Re: SE-14-00011

Thank you for the opportunity to comment on the revised mitigated determination of nonsignificance for the 2 Phase I-502 Grow Facility project on 21.12 acres, proposed by QLL Holdings, LLC. We have reviewed the environmental checklist and have the following additional comments to Ecology's letter dated February 13, 2015.

Air
Photo

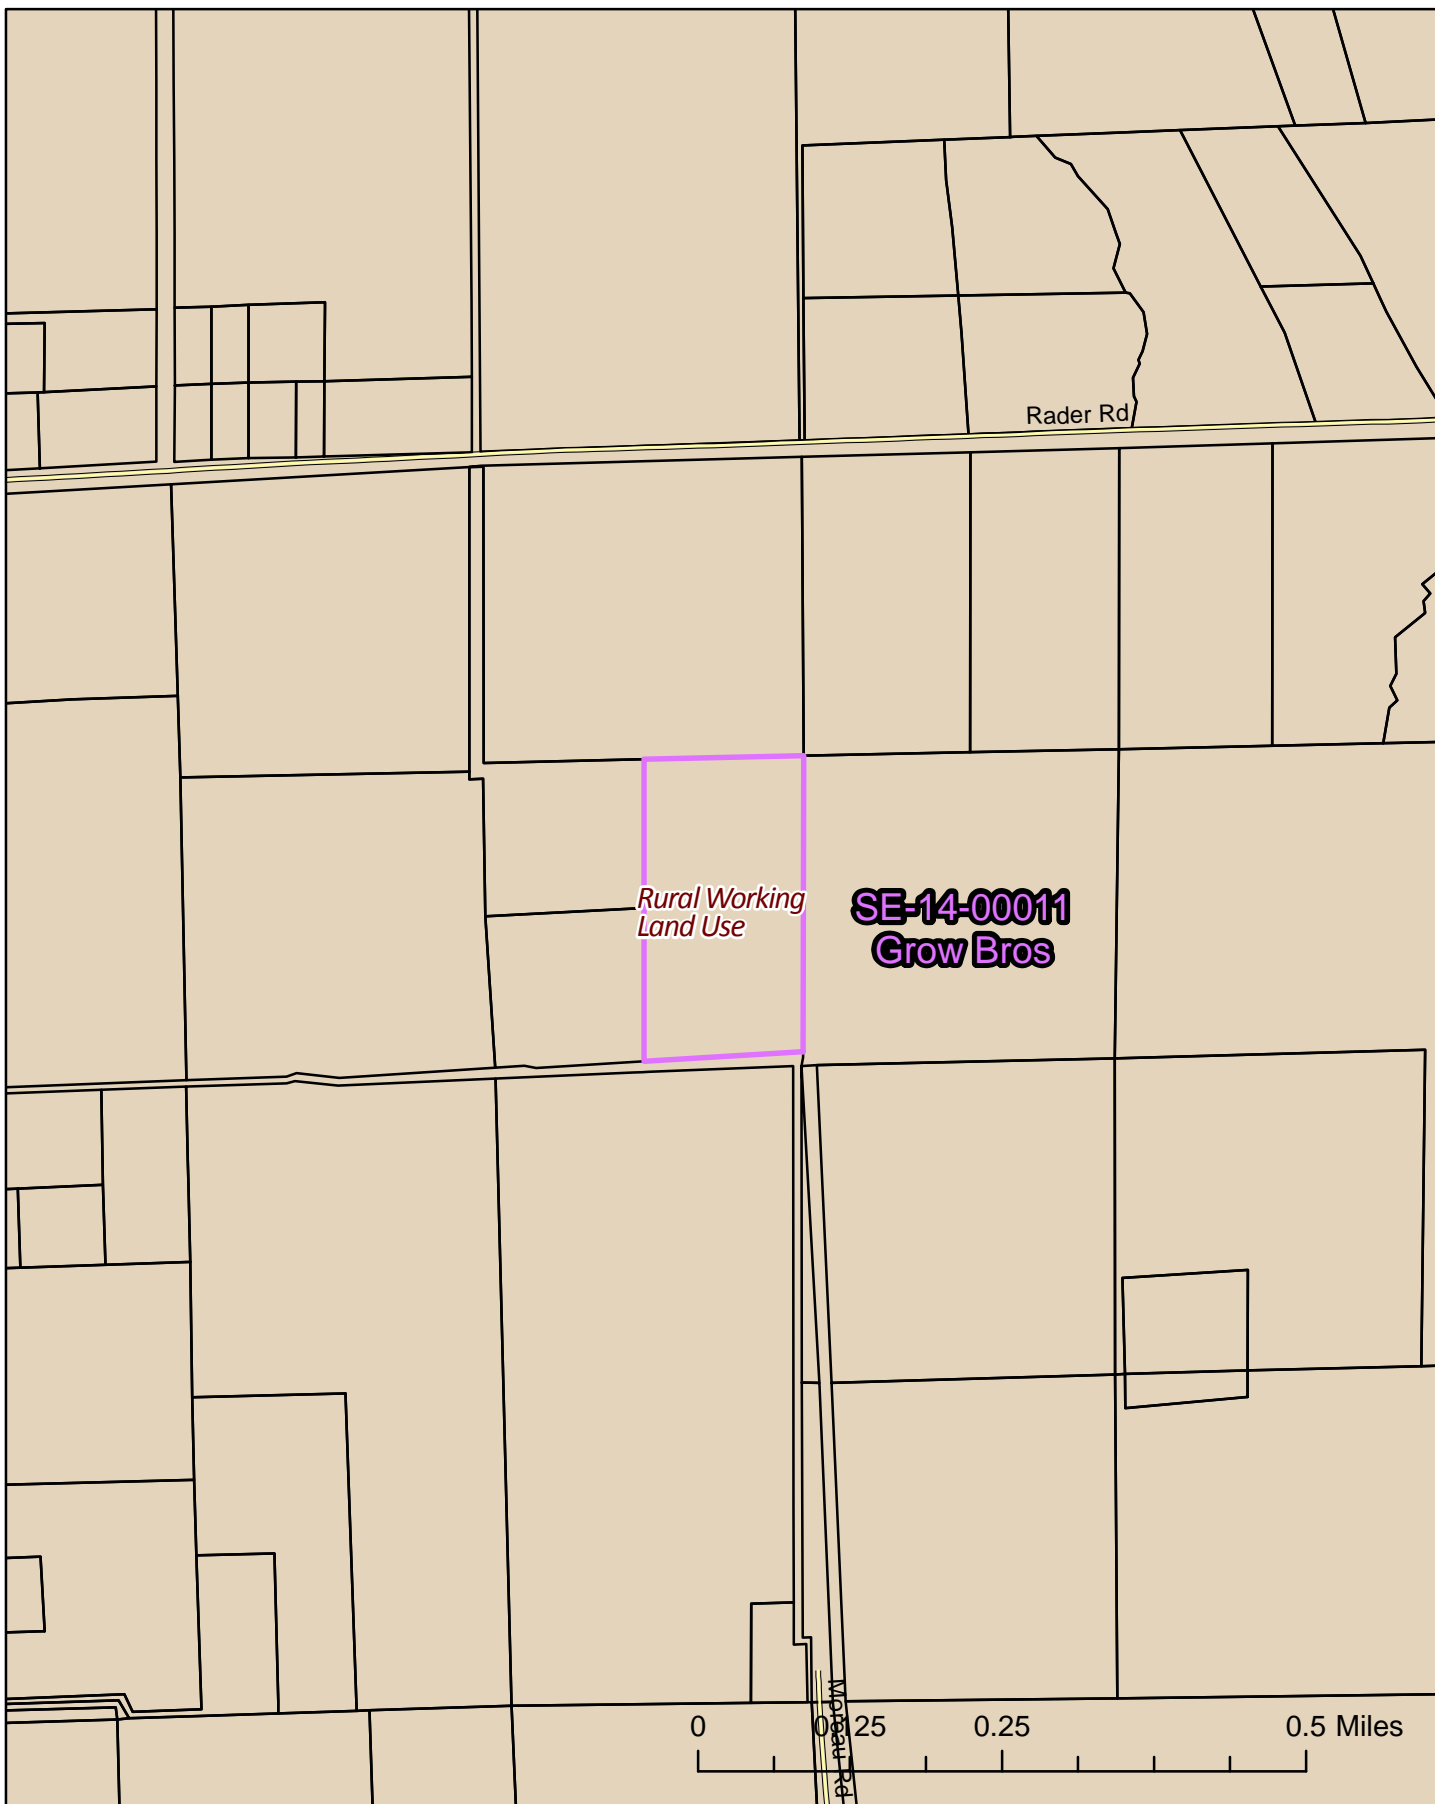
There appears to be a swale that bisects both lots and connects to the south with the Schnebly Creek system. Aerial photos show that the swale transverses the two lots from the northwest corner of lot 2 down to the southeast corner of lot 3. There is an artificially excavated pond that either day-lights groundwater or has water pumped into it. If this excavated pond is capturing a high groundwater table, then wetlands could be present in the swale. The SEPA checklist should provide information on these features and should provide information on where the groundwater table is in relationship to the surface. These low areas should be examined to determine whether wetlands are present if these areas will be filled or excavated to place developments on site. If wetlands will be impacted, then mitigation for wetland impacts should be required.

Ecology would be happy to assist the County or the applicant with a site reconnaissance to determine whether wetlands are present on the site and whether a wetland determination is needed to protect wetland functions from development activities.
